From: Richard Brown [REDACTED]
Sent: 16 January 2015 11:36
To: Janice Chapman
Subject: Re: FW: AW/334/14/HH - Single storey side extension and conversion of garage to kitchen and breakfast room at 3 A'Beckets Avenue, Aldwick

From: Janice Chapman
Sent: 14 January 2015 15:28
To: [REDACTED]
Subject: AW/334/14/HH - Single storey side extension and conversion of garage to kitchen and breakfast room at 3 A'Beckets Avenue, Aldwick

Scale 1:200

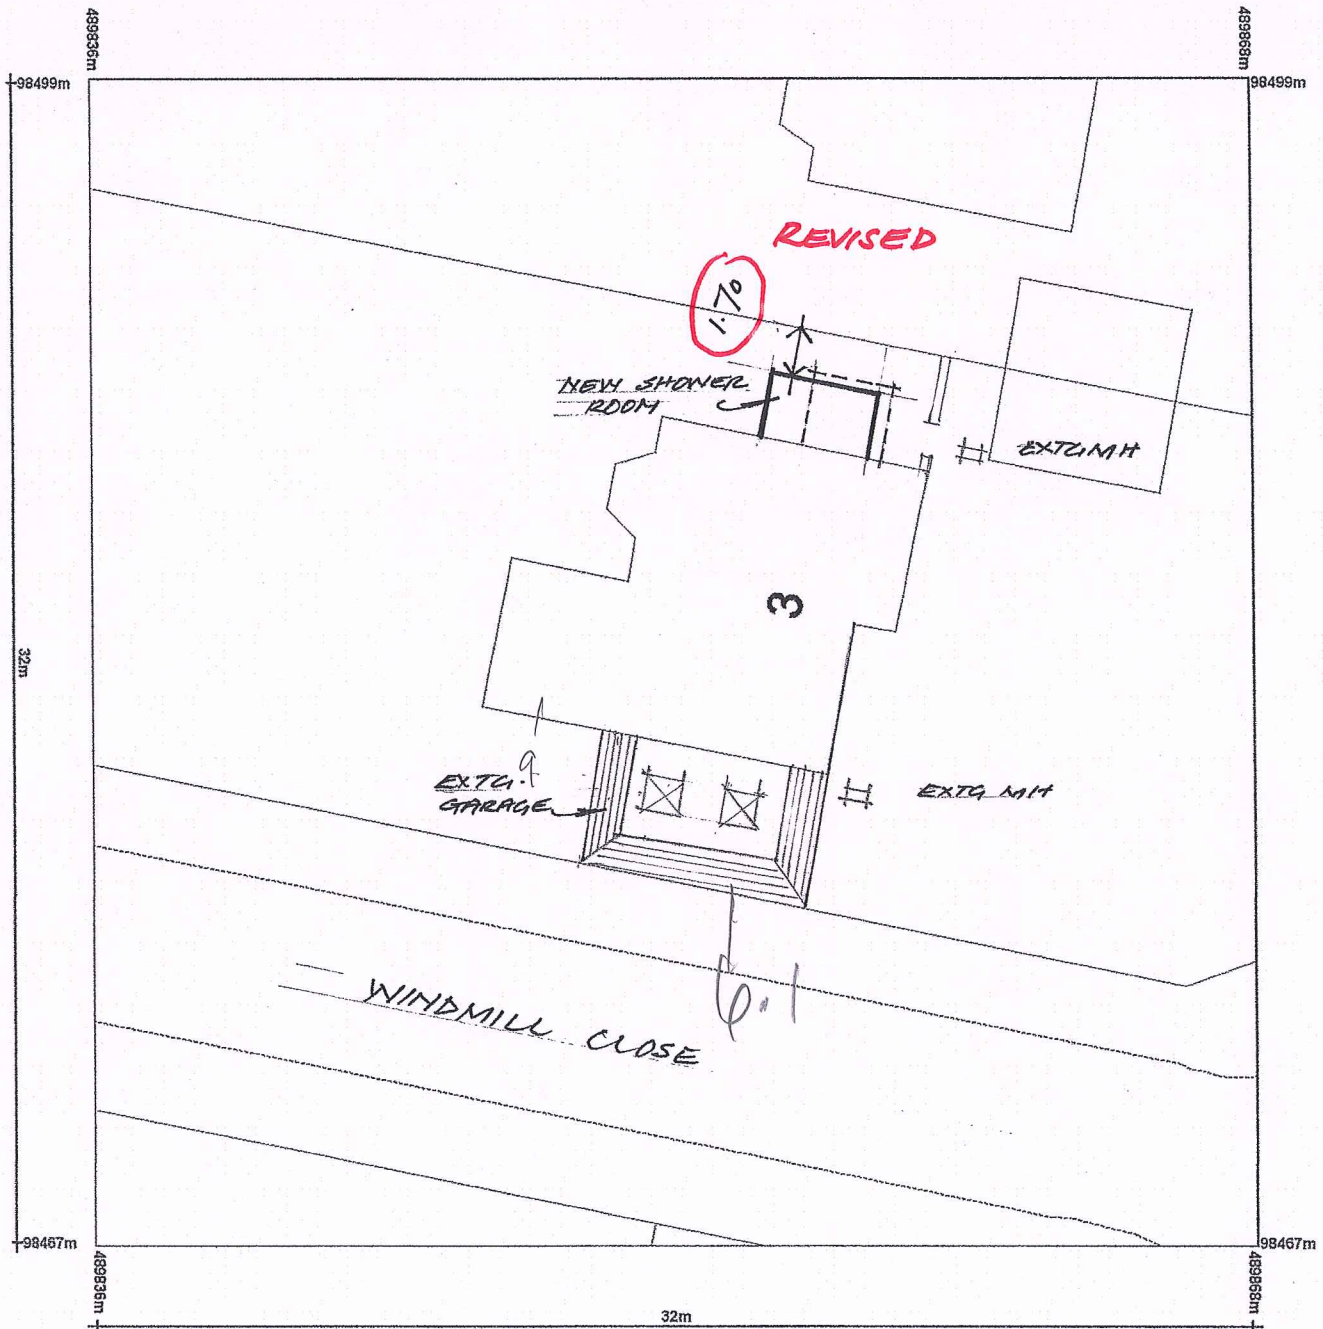
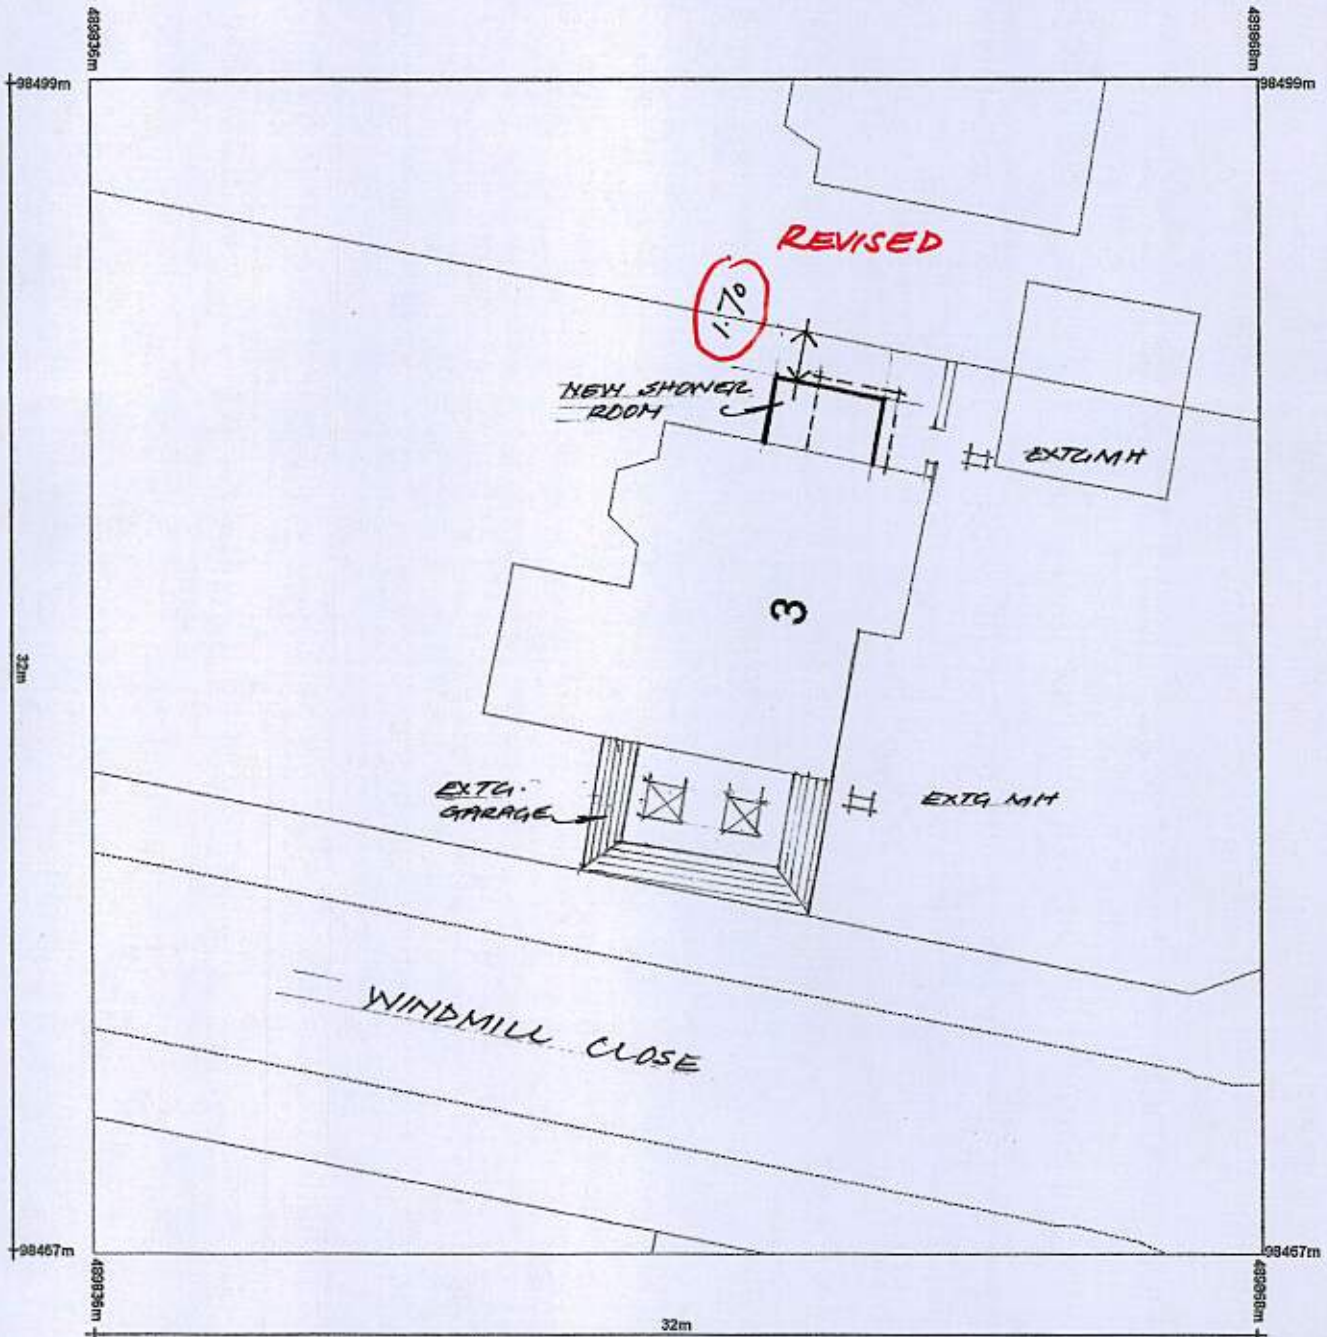
From a site inspection it was noted that the neighbouring property at No 1 A'Beckets Avenue has a single storey flat roof extension on the south side of the dwelling. Can you submit an amended 1:200 Block Plan showing this structure.

I attach a revised copy of the 1:200 block plan to include the neighbour's single storey side extension. I have to say that measuring up the adjoining property showed up an inconsistency in the OS map regarding the boundary. My revised plan is as on site including the correct dimensions to the boundaries from each property.
